Planning Consultation Request
Town and Country Planning Act 1990
APPLICATION FOR PERMISSION TO DEVELOP LAND

Application No.	2025/90578
Proposed Development:	Change of use and internal alterations of first, second and third floors to form 5 apartments (Listed Building within a Conservation Area)
Location:	Prudential House, 69, New Street, Huddersfield, HD1 2BQ
OS Map Reference	SE 414441.5748 416469.8781
Applicant/Agent:	Northern Design Partnership
Class:	Minor Developments
Site Area (sq. m):	180.0

**Consultation Response from KC,
Conservation & Design**

**Change of use and internal alterations of first, second and third floors to form 5 apartments
(Listed Building within a Conservation Area)**

IF IN ANY DOUBT PLEASE ASK THE ARCHITECT FOR CLARIFICATION.
DO NOT SCALE FROM DRAWING. ALL DIMENSIONS TO BE CHECKED ON SITE.
THE COPYRIGHT FOR THESE DRAWINGS REMAINS THE PROPERTY OF THE ARCHITECT. THEY MUST NOT BE REPRODUCED IN ANY WAY WITHOUT THE ARCHITECT'S PRIOR WRITTEN CONSENT.

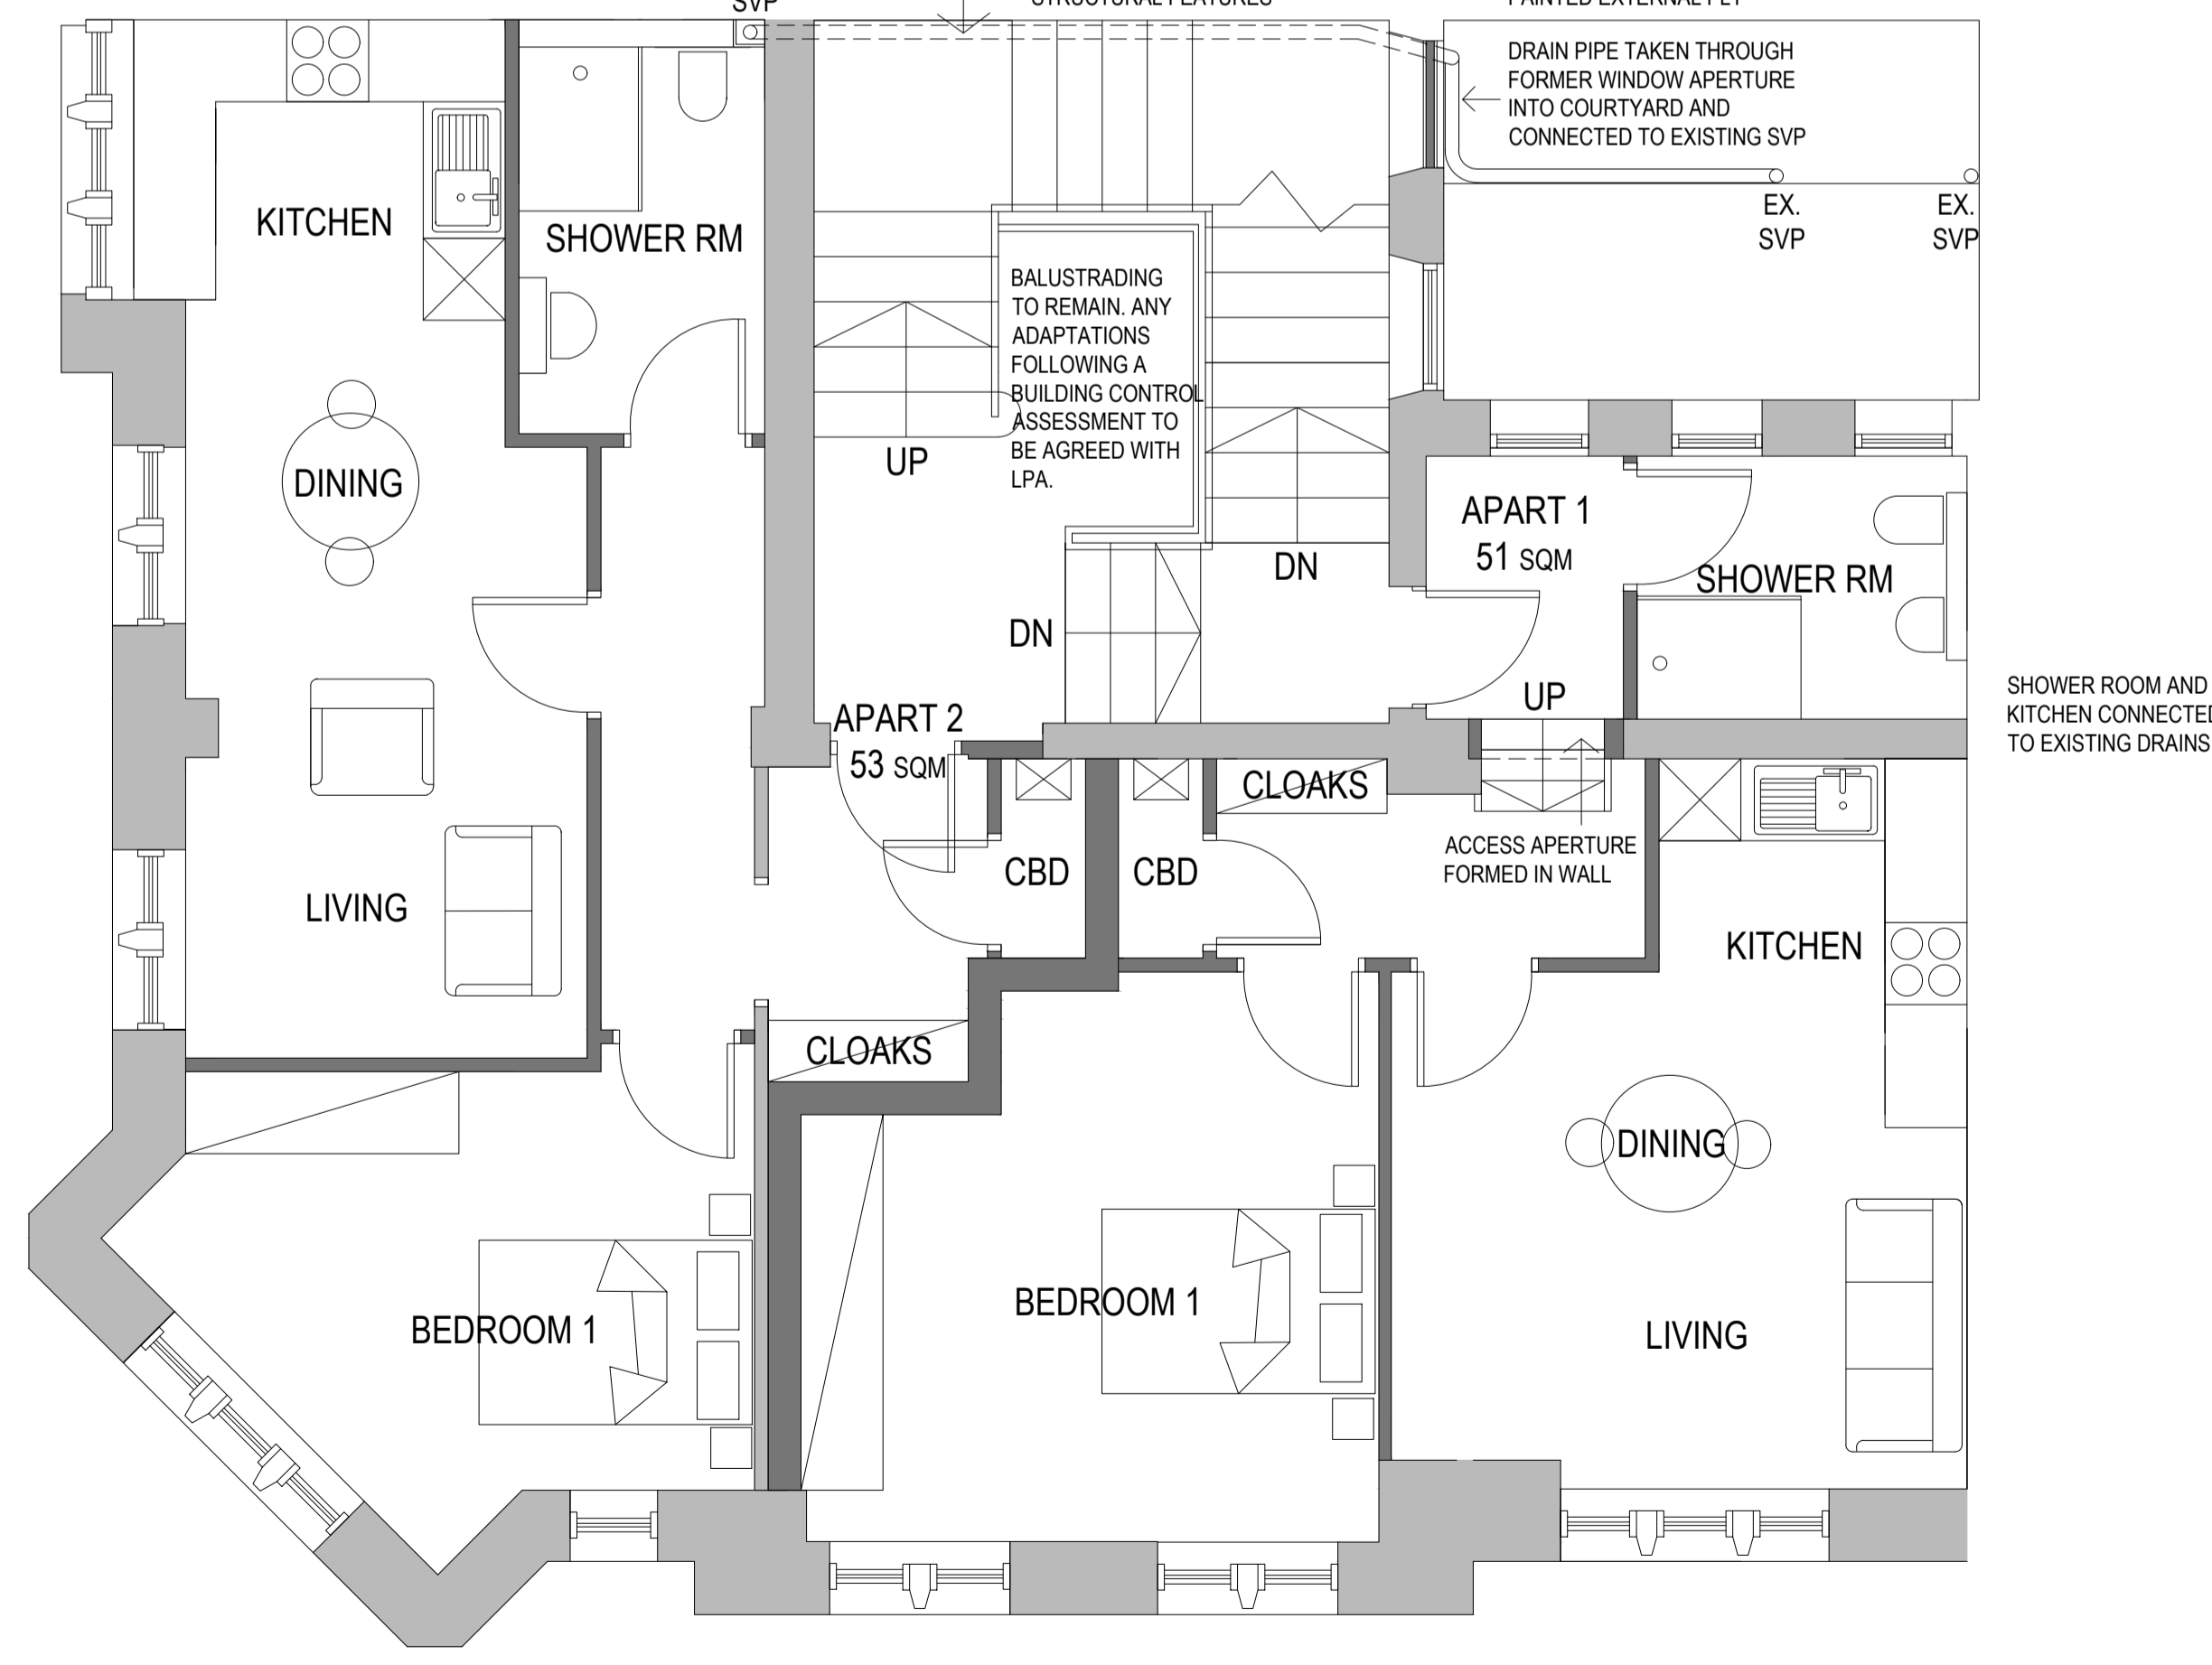
As discussed on site, the agent has agreed to add extra annotation to the plans to indicate the following;

1. The 2 fireplaces on the top floor will be retained and reinstated.
2. The mosaic entrance flooring and wooden parquet flooring within flats will be retained (under new floor coverings where necessary).
3. Ceiling decoration including cornices and picture rails will be retained, any new suspended ceilings will be set below the cornices to avoid any damage.
4. Original internal panelled doors will be retained where possible inside flats.
5. Original windows and external doors will be retained (but secondary glazing is acceptable).
6. Window surrounds and panelling below windows shall be retained.
7. Original deep skirting boards shall be retained.

8. The staircase and balustrading shall be retained. Any amendments that may be required to satisfy Building Regulations shall be submitted in writing with detailed drawings showing the handrail and any extra restraint requirements.

The proposed plans should be amended and annotated to indicate that the features set out above will be preserved and retained.
